RE: Staff Review Comments for Amendments to Approved Plans for 130 Eastern Promenade

Project Name: 130 Eastern Promenade Plan Amendments
Address: 130 Eastern Promenade
Applicant: Eileen Simko-Minte
Planner: Nell Donaldson

Project ID: 2013-236
CBL: 003 C001001

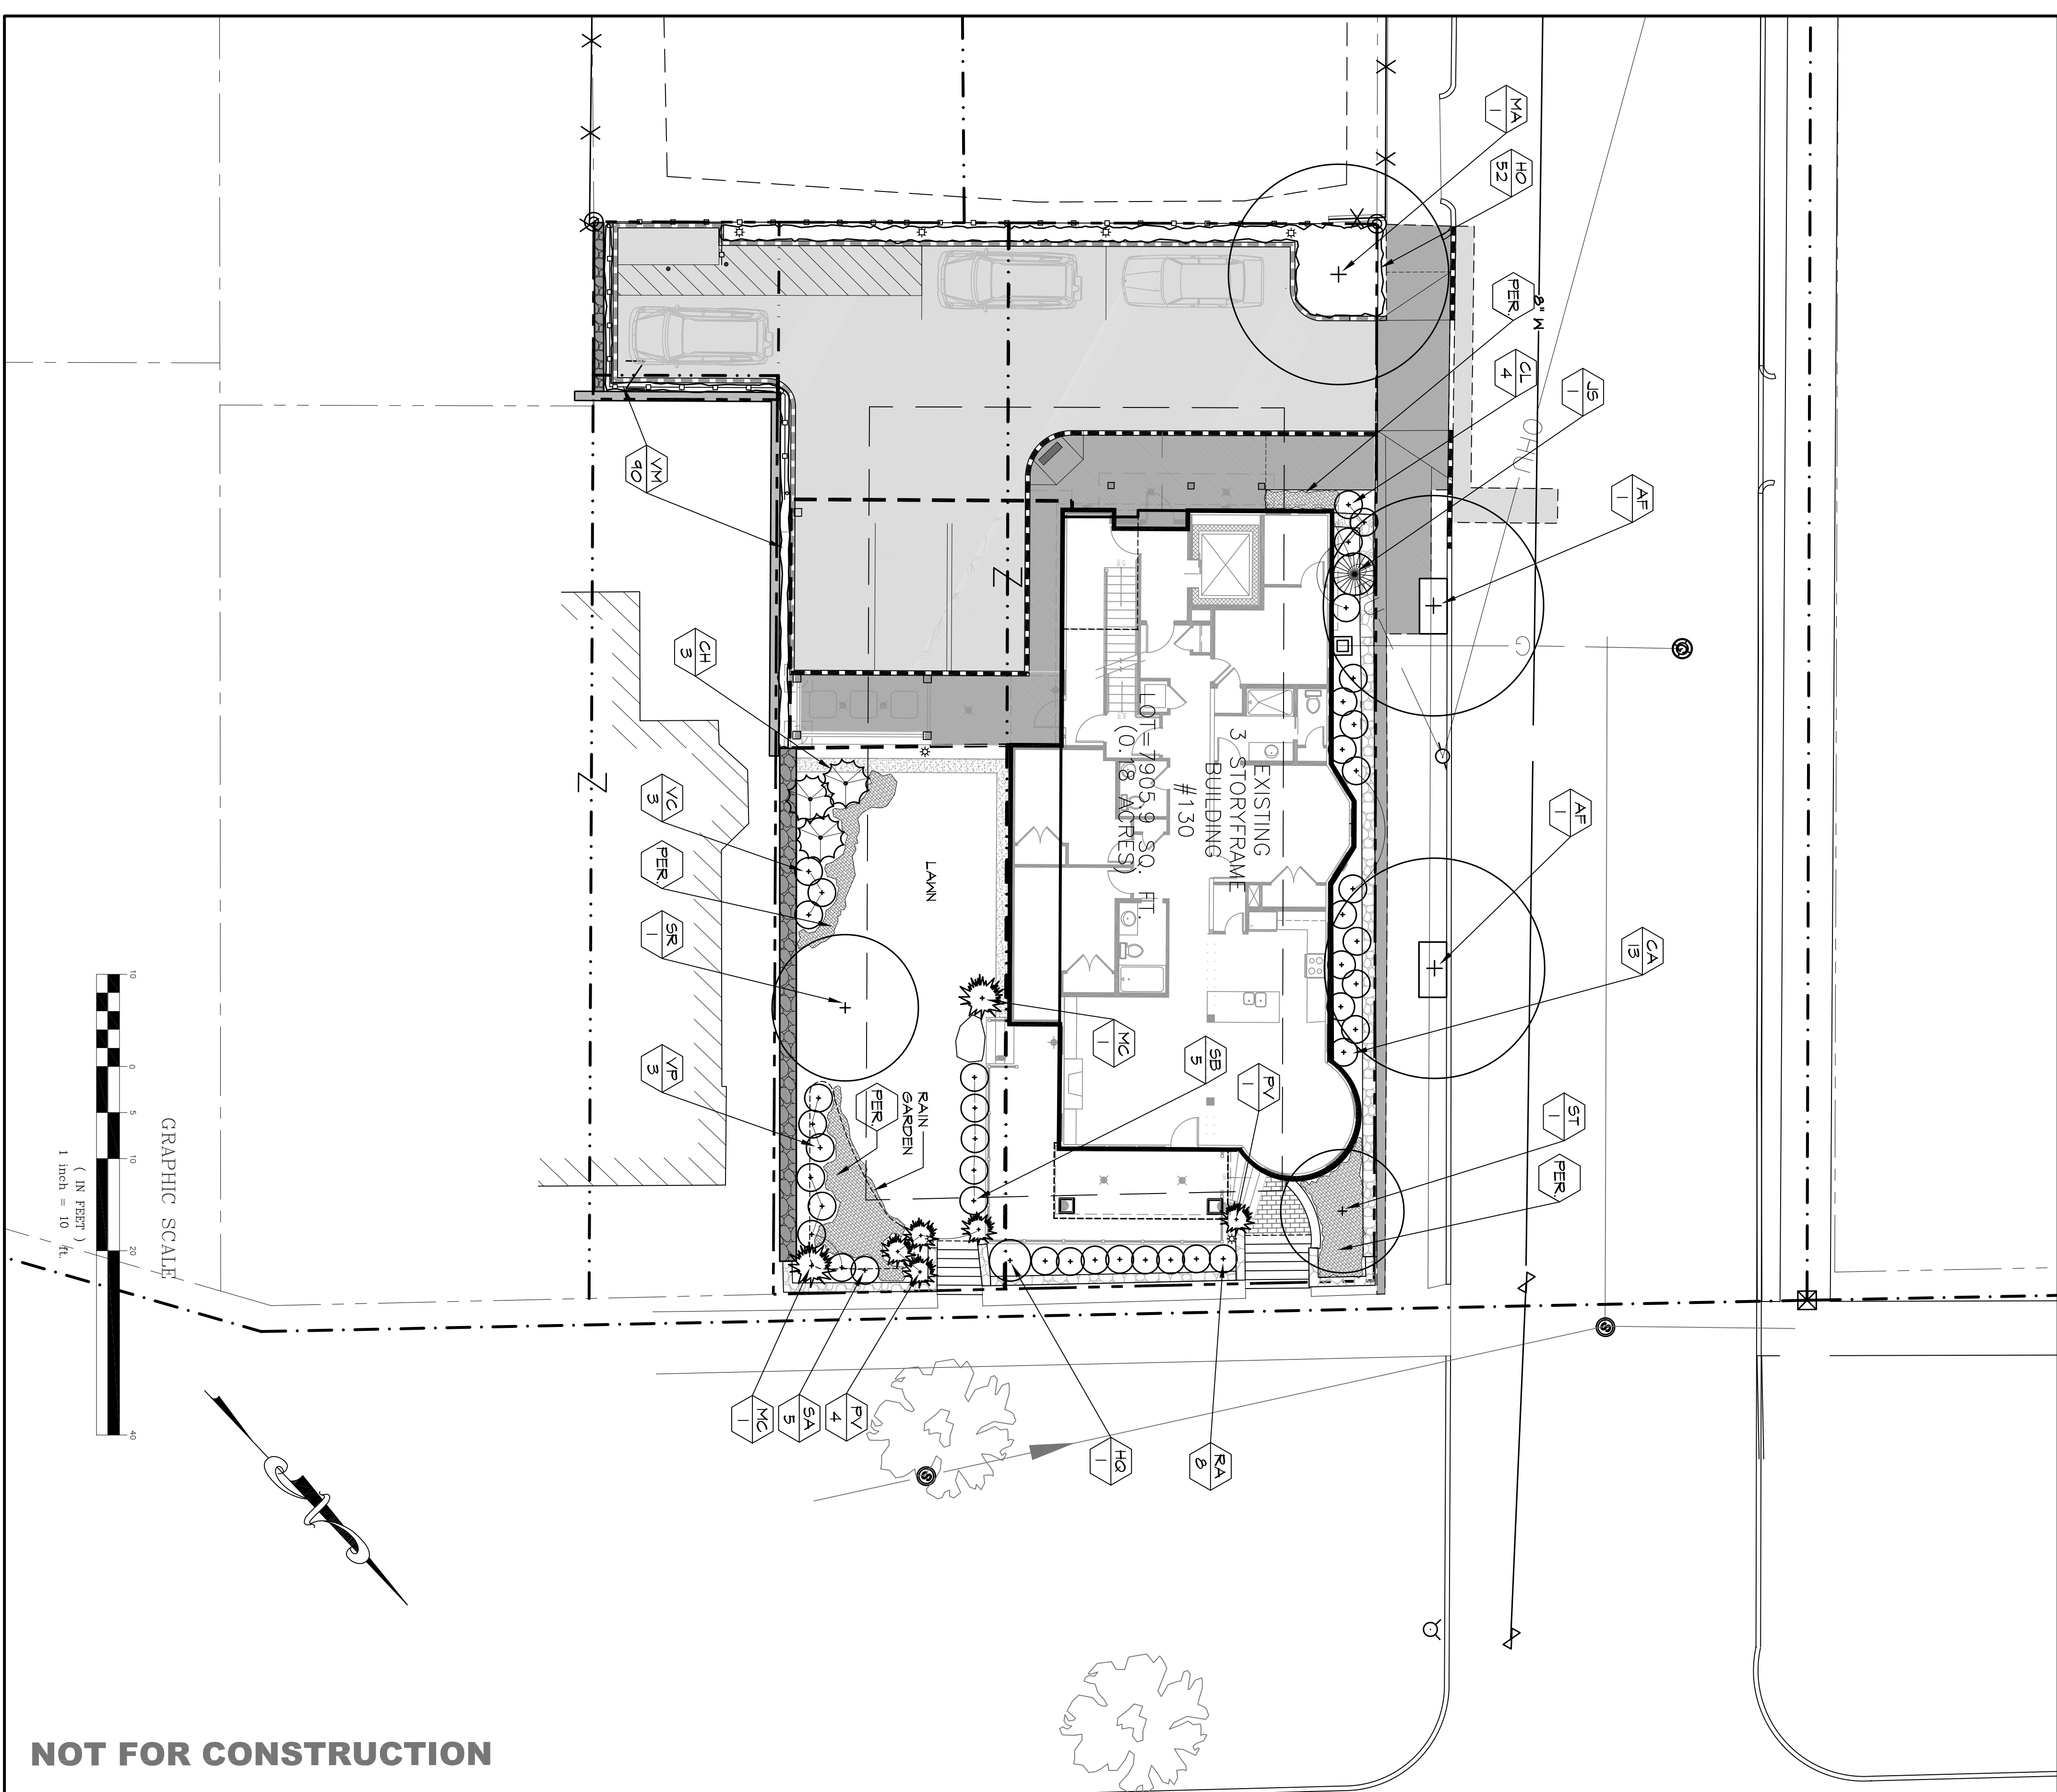
The project proposes two new street trees along Wilson Street. Due to overhead utility lines overhead on the second tree (away from E Prom) that tree should be a smaller tree such as Sargent Cherry, Japanese Tree Lilac vs the 'Armstrong' Red Maple as shown. The maple is good for the tree closest the prom with no overhead wires.

The project should review tree planter width recommended at 3.5' min and ideal at 4'. Sidewalk needs to comply with ADA standards on width. This may require a cut-out in the sidewalk and tree grate.

Review and increase plant sizes for the 1 gallon plant sizes to 3 gallon size on 'Grow-low sumac, the crab-apple recommendation would be "Adirondack". Options for the proposed Japanese Tree Lilac could also be dogwood or crab-apple.

Please extend the proposed tree planter cut out to 3.75' wide from inside face of curb to be consistent with cut outs up the street.

The back property line near the proposed parking should include a low wood fence to screen car parking along with a complement of landscape treatment. The landscape treatment or planting should include shrub planting to help as a screen. The ideal height would be 5 - 6', perhaps 'Korean' Lilac size... the available planter width along the property line should be widened to perhaps 3' if possible to accommodate this planting space. Narrowing the proposed paved walk space between the drive and building could be reduced perhaps to find space.

Could the trash dumpster be moved up toward the street equal to the car parking area, approximately 6 - 8' to provide landscape space in the corner?

L-5.1

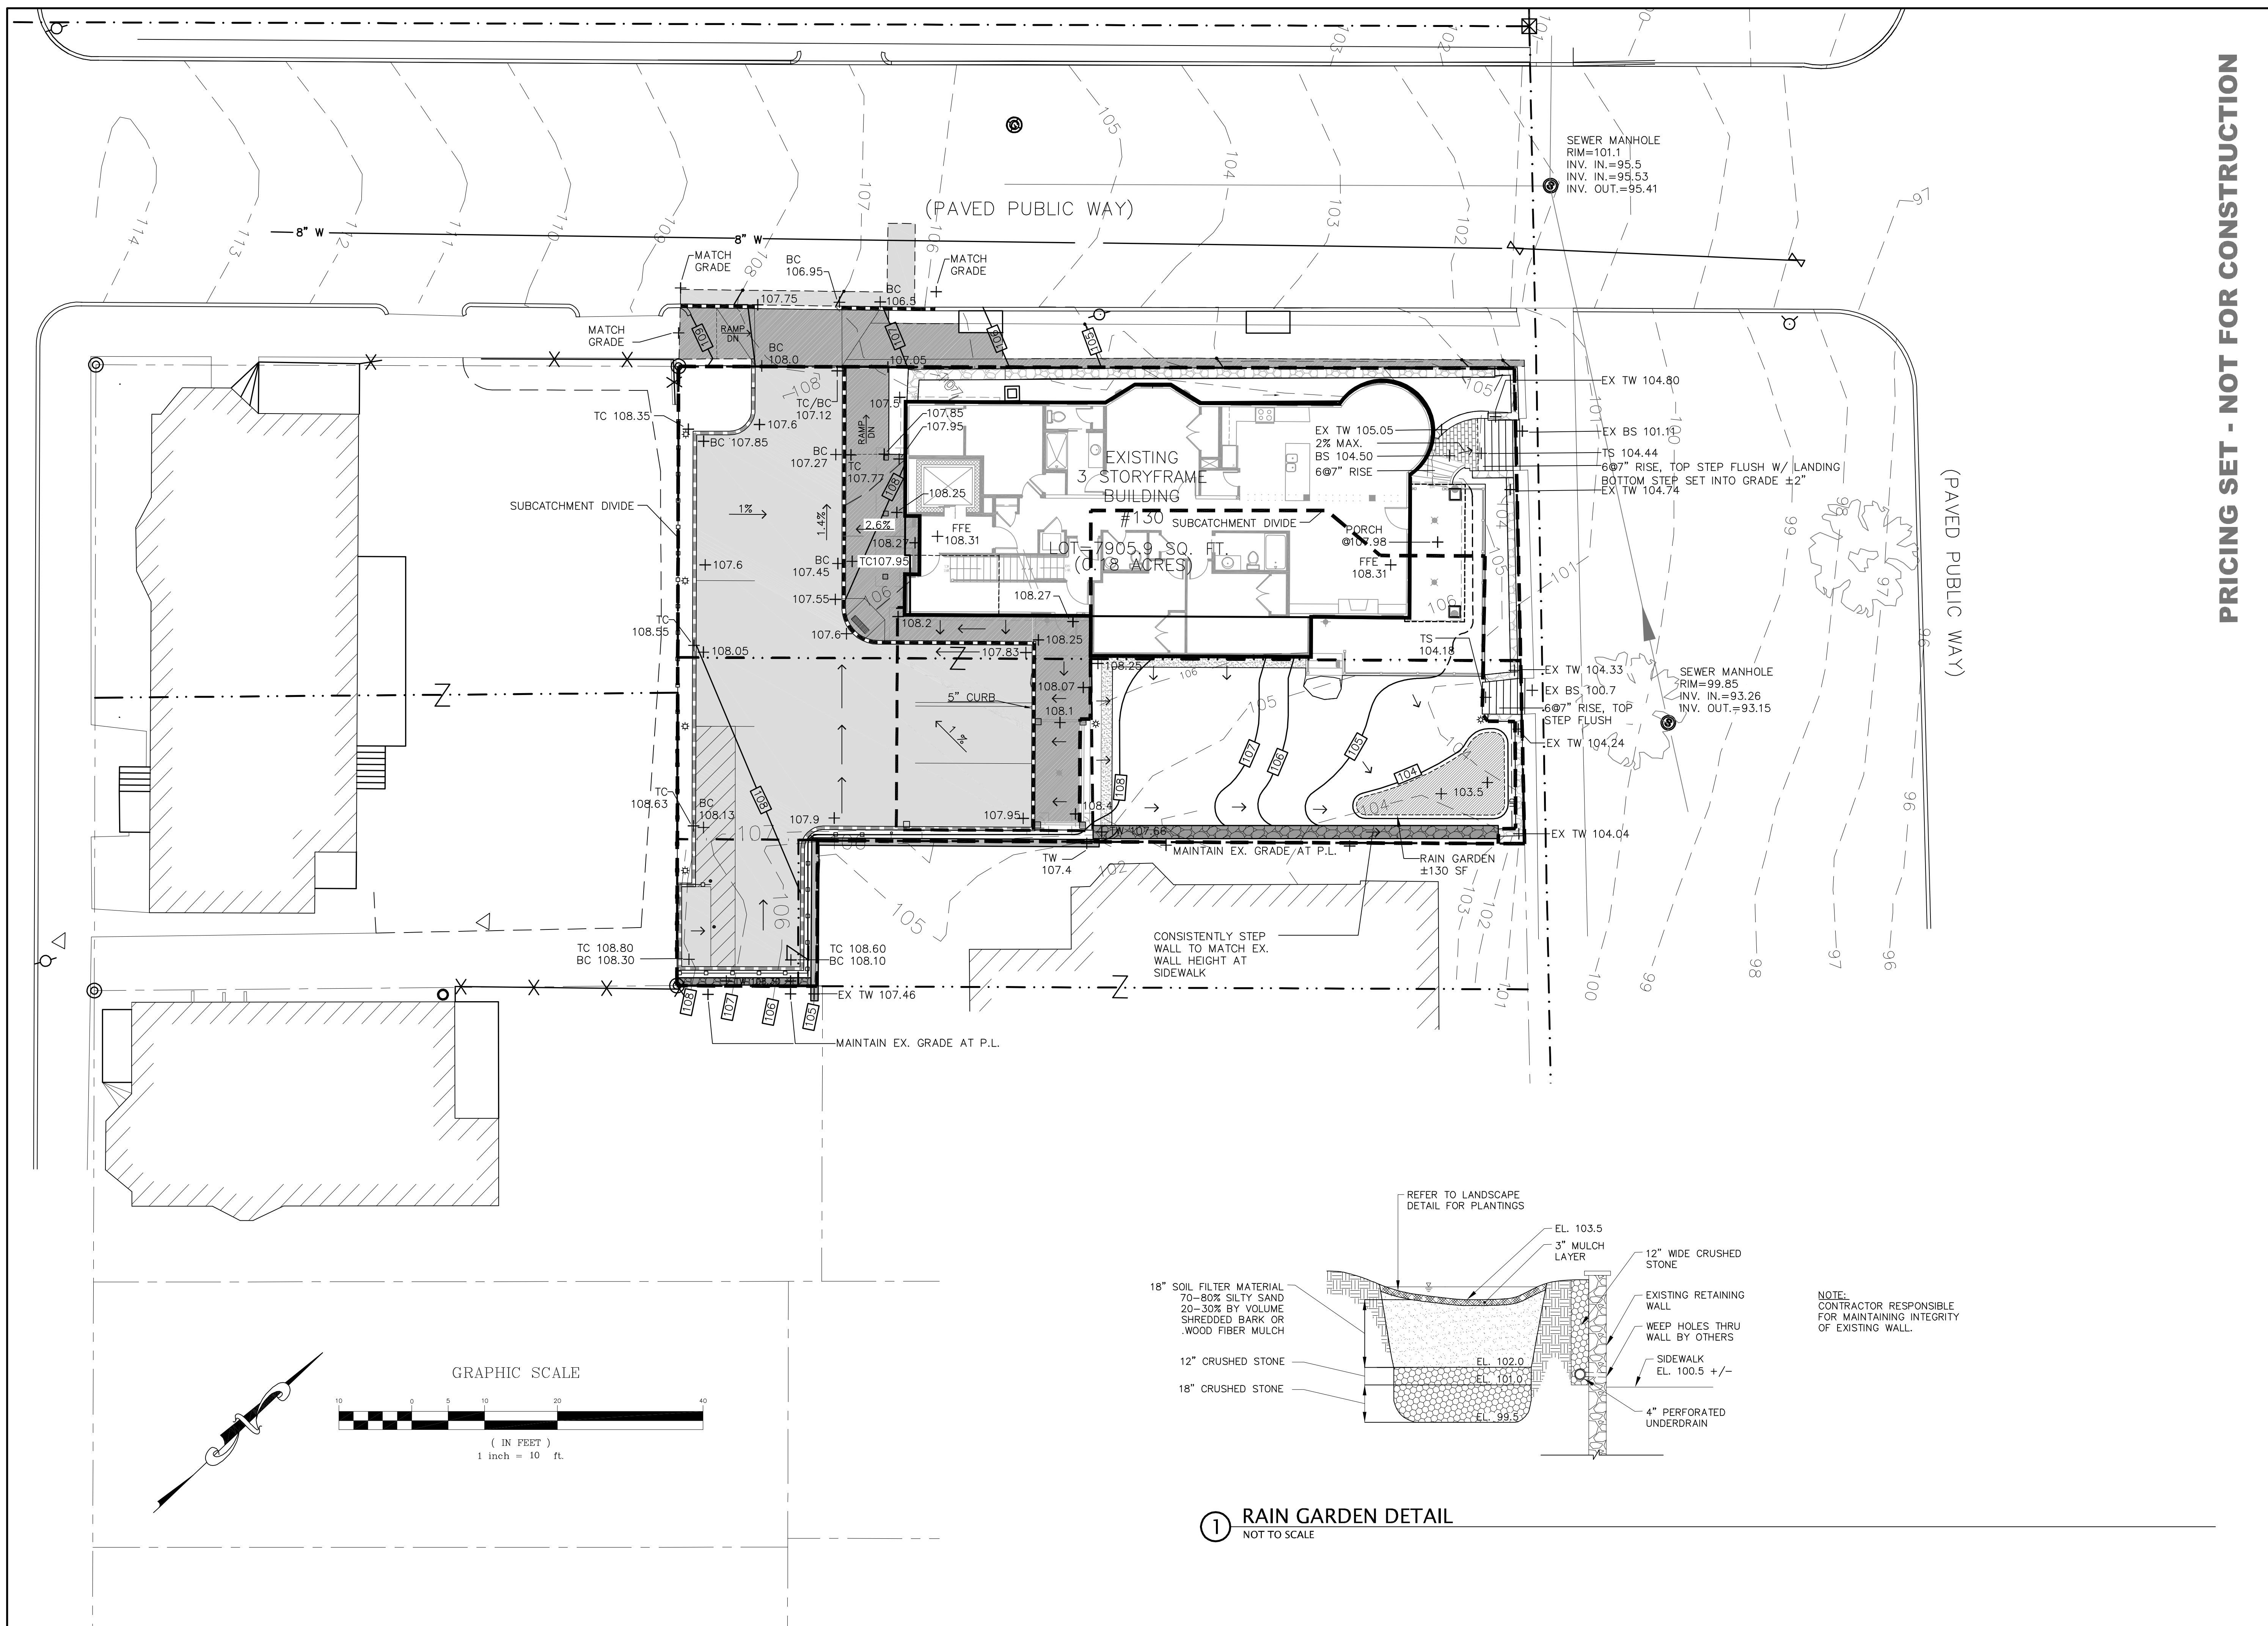
The rain garden details on sheet D-1.0 and the retaining wall detail on L-5.1 indicate that an underdrain will exist below the rain garden and at the base of the retaining wall; however, no underdrains are depicted on the site plans. If an underdrain is required for these systems, we encourage day-lighting the underdrain(s) in lieu of a direct connection to the combined sewer; clarification should be provided on the plans and/or details.
